**Re: Edith 4-Plex
725 Edith Blvd SE
Traffic Circulation Layout
Architect's Stamp 11-30-2021 (K14-D228)**

Based upon the information provided in your submittal received 03-04-2022, the above referenced plan cannot be approved for Building Permit until the following comments are addressed:

STATE OF NEW MEXICO RICHARD P. [Signature] No. 1240 11/30/2017 REGISTERED ARCHITECT	RBA ARCHITECTURE PC 1000 E. 10th Ave. Ste. 200 Phoenix, AZ 85001 www.rbaaz.com
DATE	SHEET NUMBER
11-30-2021	AS-1.0

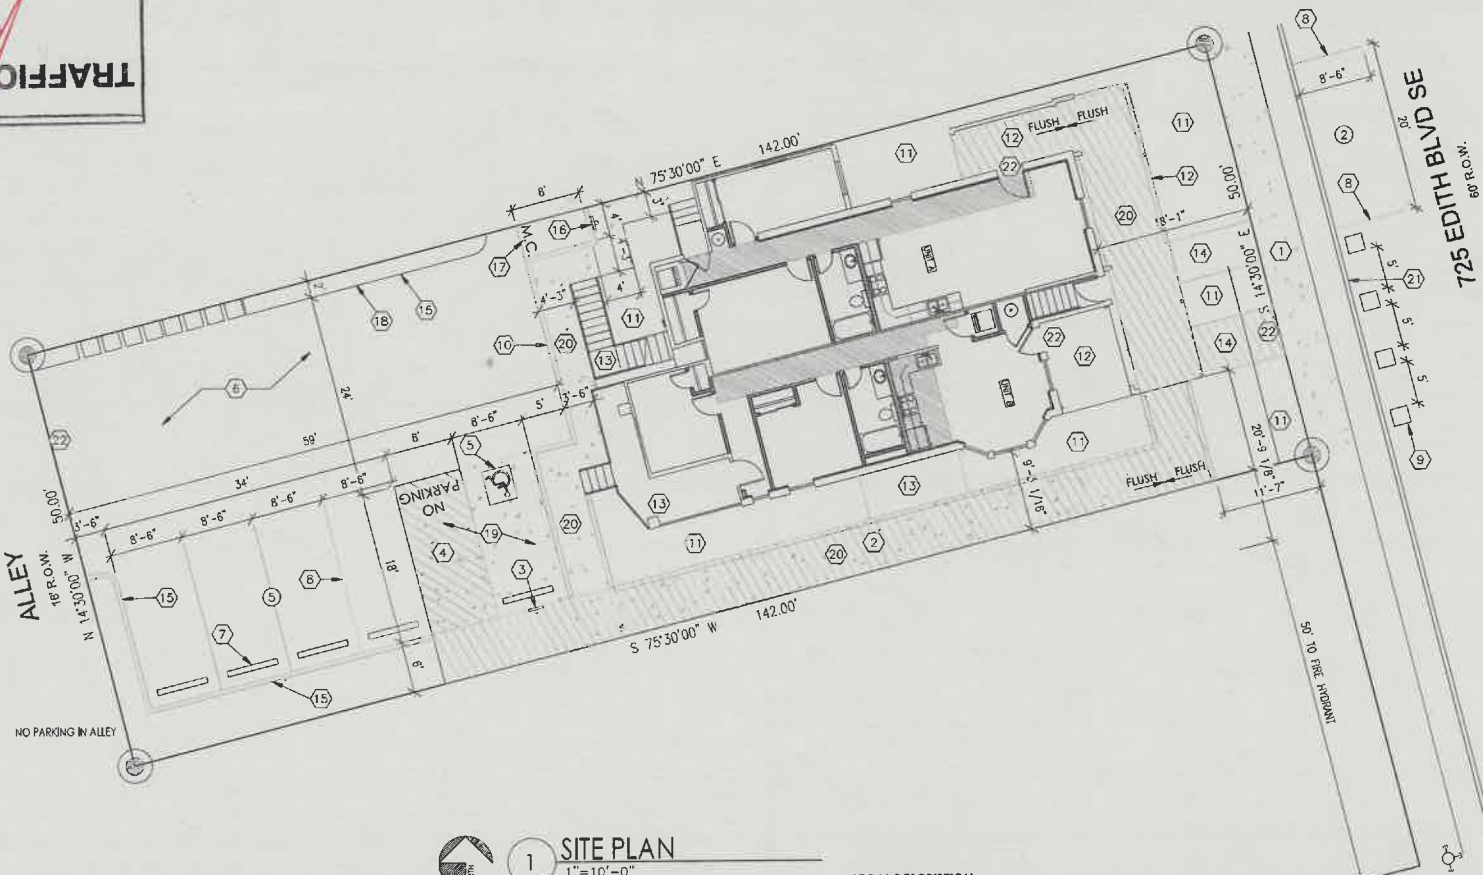
- PO Box 1293
Albuquerque
NM 87103
www.cabq.gov
1. Provide proposed concrete design (Keyed 19). Thickness should be great 6 inch or greater. Include dowels if required by design.
 2. **Detail A10/AS-2.):** Provide slopes for landing (50:1 max) and specify ramp run as 12:1 **MAX.**
 3. **Motorcycle parking space:** Label pavement MC.
 4. Curbing should be installed to delineate landscape, and pedestrian ways and identify points of access. Please call out detail and location of barrier curb.
 5. Provide a copy of refuse approval.
 6. Fire Department: An approval Fire 1 plan needs to be provided **(If applicable by FD).**
 7. Add a note stating "All broken or cracked sidewalk must be replaced with sidewalk and curb & gutter." A build note must be provided referring to the appropriate City Standard drawing (2430 & 2415A).
 8. Please provide a letter of response for all comments given.
